J.D.'S HAPPY HEIGHTS SHORT PLAT (SP-07-119)
COMPLIANCE DOCUMENT

KITITAS COUNTY	DATE	JOB NO.
DWN BY T.R./G.W.	10/2020	07102
CHKD BY D.N./D.L.P.	SCALE 1" = 100'	SHEET 1 OF 2

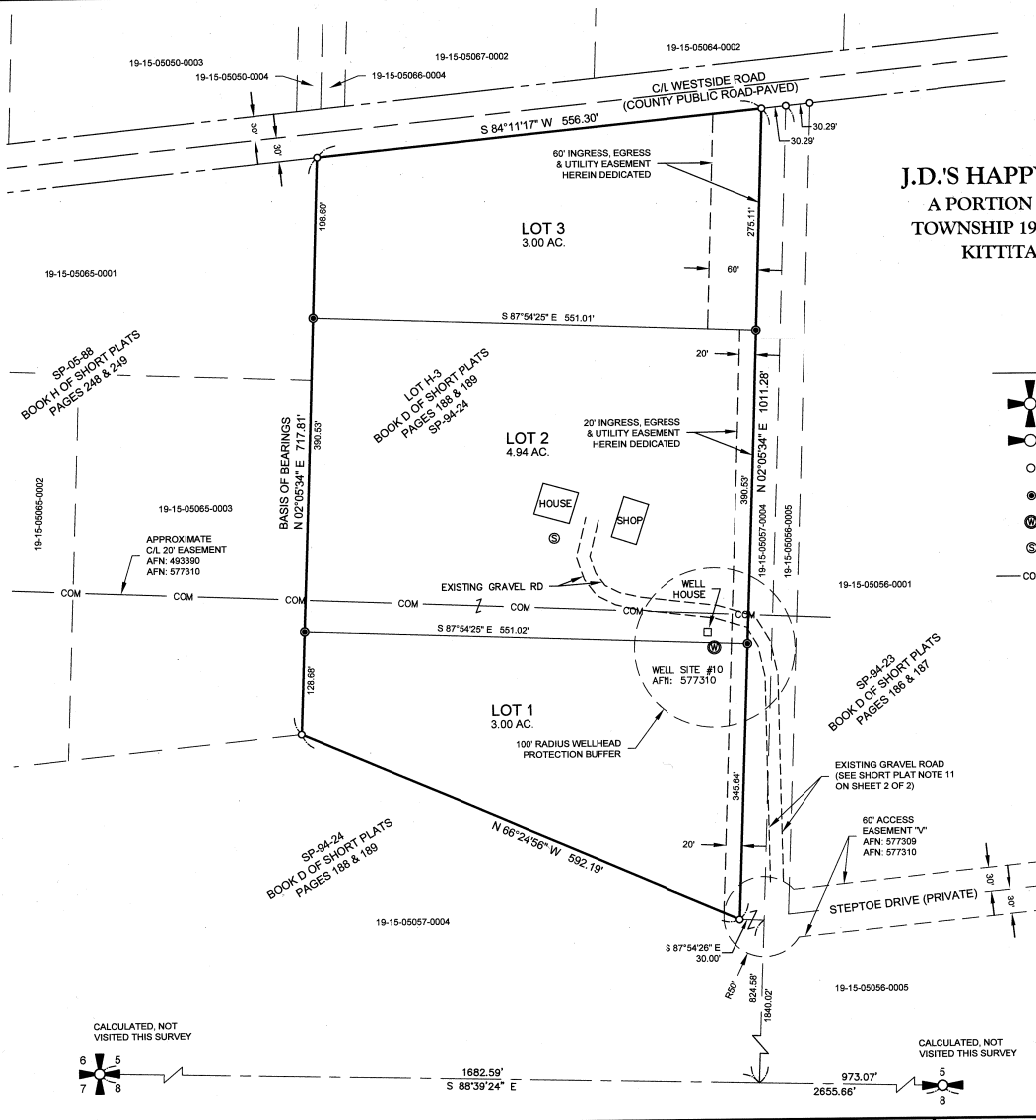
9-10-2007	RANDY – PUBLIC WORKS	ENGINEERING AND SURVEYING. THE APPROVED DESIGN SHALL BE INCORPORATED INTO THE REQUIRED ROAD IMPROVEMENTS FOR STEPTOE DRIVE AND SHALL BE INCLUDED IN THE REQUIRED ROAD CERTIFICATION. ACCESS TO LOT 2: THE EXISTING ACCESS TO LOT 2 APPEARS TO ORIGINATE FROM THE CUL-DE-SAC LOCATED AT THE END OF STEPTOE DRIVE AND CROSSES THE PARCEL TO THE EAST. NO EASEMENT IS SHOWN ON THE EXISTING ACCESS TO LOT 2. THE ACCESS EASEMENT FOR LOT 2 SHALL BE CLEARLY DEPICTED ON THE FACE OF THE PLAT. THE AUDITOR FILE NUMBER SHALL BE SHOWN FOR ANY ESTABLISHED EASEMENT PROVIDING ACCESS TO THIS DEVELOPMENT. PRIVATE ROAD MAINTENANCE AGREEMENT: THE APPLICANT SHALL MEET ALL APPLICABLE CONDITIONS OF ANY PRE-ESTABLISHED OR REQUIRED PRIVATE ROAD MAINTENANCE AGREEMENTS. LOT CLOSURE: IT IS THE RESPONSIBILITY OF THE PROFESSIONAL LICENSED SURVEYOR (PLS) TO ENSURE THE LOT CLOSURES ARE CORRECT AND ACCURATE. ACCESS PERMIT: AN APPROVED ACCESS PERMIT SHALL BE REQUIRED FROM THE DEPARTMENT OF PUBLIC WORKS PRIOR TO CREATING ANY NEW DRIVEWAY ACCESS OR PERFORMING WORK WITHIN THE COUNTY ROAD RIGHT OF WAY. ADDRESSING: CONTACT THE KITTITAS COUNTY RURAL ADDRESSING COORDINATOR AT (509) 962-7523 TO OBTAIN ADDRESSES PRIOR TO OBTAINING A BUILDING PERMIT. A PARCEL CANNOT RECEIVE A BUILDING PERMIT OR UTILITIES UNTIL SUCH PARCEL IS IDENTIFIED WITH A 911 ADDRESS. FIRE PROTECTION: CONTACT THE KITTITAS COUNTY FIRE MARSHAL REGARDING ANY ADDITIONAL ACCESS REQUIREMENTS FOR EMERGENCY RESPONSE. MAILBOX PLACEMENT: MAILBOXES MUST BE APPROVED BY U.S. POSTAL SERVICE. MAILBOX LOCATIONS ARE SITE SPECIFIC. CONTACT YOUR LOCAL POST OFFICE FOR LOCATION AND DESIGN STANDARDS BEFORE BEGINNING CONSTRUCTION. MAILBOX PLACEMENT: THE U.S. POSTAL SERVICE REQUIRES THAT PRIVATE ROADS WITH 6 OR MORE RESIDENCES INSTALL USPS APPROVED CLUSTER BOX UNITS (CBUS) AT A SAFE LOCATION AT THE MOUTH OF THE PRIVATE ROAD. CONTACT YOUR LOCAL POST OFFICE FOR LOCATION AND ADDITIONAL DESIGN REQUIREMENTS BEFORE BEGINNING CONSTRUCTION. PRIVATE ROADS SHALL MEET THE MINIMUM ACCESS REQUIREMENTS OF THE INTERNATIONAL FIRE CODE AS ADOPTED BY THE COUNTY, AND SHALL BE DESIGNED AND CONSTRUCTED IN CONFORMANCE WITH AASHTO GUIDELINES FOR GEOMETRIC DESIGN OF VERY LOW-VOLUME LOCAL ROADS (ADT<400) 2003, AS NOW EXISTS OR HEREAFTER AMENDED, AND SHALL BE INSPECTED AND CERTIFIED BY A LICENSED PROFESSIONAL ENGINEER FOR CONFORMANCE WITH THE ABOVE REFERENCED STANDARDS. IN THE ALTERNATIVE, AN APPLICANT MAY REQUEST THE PRIVATE ROADWAY TO BE INSPECTED AND SUBJECT TO THE APPROVAL OF THE PUBLIC WORKS DIRECTOR. IF CERTIFICATION BY THE PUBLIC WORKS DIRECTOR/COUNTY ENGINEER IS DESIRED, SUBMISSION OF ROAD PLANS AND NECESSARY TESTING DOCUMENTATION THAT CONFIRMS COMPLIANCE WITH KITTITAS COUNTY ROAD STANDARDS IS REQUIRED, AND SERVICES WILL BE PERFORMED ON A REIMBURSABLE BASIS, AND PERMANENTLY ESTABLISHED BY AN EASEMENT RECORDED WITH THE KITTITAS COUNTY AUDITOR OR RIGHT-OF-WAY, PROVIDING LEGAL ACCESS TO EACH AFFECTED LOT, DWELLING UNIT, OR BUSINESS, AND WILL NOT RESULT IN LAND LOCKING OF EXISTING OR PROPOSED PARCELS, AND	FINAL SHORT PLAT SHOWS ALL NECESSARY EASEMENTS.

VICINITY MAP - N.T.S.

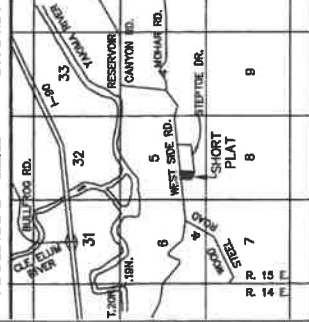
9-4-2007	HOLLY-KC HEALTH DEPT	STEPTOE DRIVE SHALL BE SHOWN ON THE VICINITY MAP.	STEPTOE DRIVE IS NOW SHOWING ON THE VICINITY MAP	
9-10-2007	RANDY- PUBLIC WORKS	RD IMPROVEMENTS/BACKGROUND:	APPLICANT WILL BOND FOR THESE IMPROVEMENTS.	
9-10-2007	RANDY- PUBLIC WORKS	THE SHORT PLAT PROPOSES SUBDIVIDING LOT H-3 OF THE ORIGINAL WESTSIDE HEIGHTS NO. 8 SHORT PLAT 94-24 INTO (2) 3 ACRE LOTS AND (1) 4.94. THE ORIGINAL WESTSIDE HEIGHTS NO. 8 SHORT PLAT 94-24 WAS APPROVED IN 1994 WITH THE STIPULATION THAT "IF THESE LOTS ARE TO BE FURTHER SUBDIVIDED, PROVISIONS MUST BE MADE FOR PUBLIC ROADS AND THE PRIVATE ROADS WILL HAVE TO BE IMPROVED TO CURRENT COUNTY ROAD STANDARDS FOR PUBLIC ROADS" - (PLAT NOTE 11). RECENTLY, ANOTHER OF THE WESTSIDE HEIGHTS ORIGINAL SHORT PLATS WAS SUBDIVIDED. IT WAS DETERMINED THAT IF ANY OF THE LOTS WITH THESE ORIGINAL WESTSIDE HEIGHTS WERE FURTHER SUBDIVIDED THAT THE ROAD WOULD BE REQUIRED TO BE UPGRADED TO A HARD SURFACE ROAD. (BST OR ACP). IN THE CASE OF J.D.'S HAPPY HEIGHTS SHORT PLAT, STEPTOE DRIVE SHALL BE REQUIRED TO BE UPGRADED TO A HARD SURFACE ROAD (EITHER BST OR ACP) FROM THE INTERSECTION OF WESTSIDE ROAD, SOUTH, TO THE "T" INTERSECTION OF STEPTOE DRIVE, THEN WEST, TO THE TERMINUS OF STEPTOE DRIVE, INCLUDING THE CUL-DE-SAC AT THE END OF STEPTOE DRIVE.
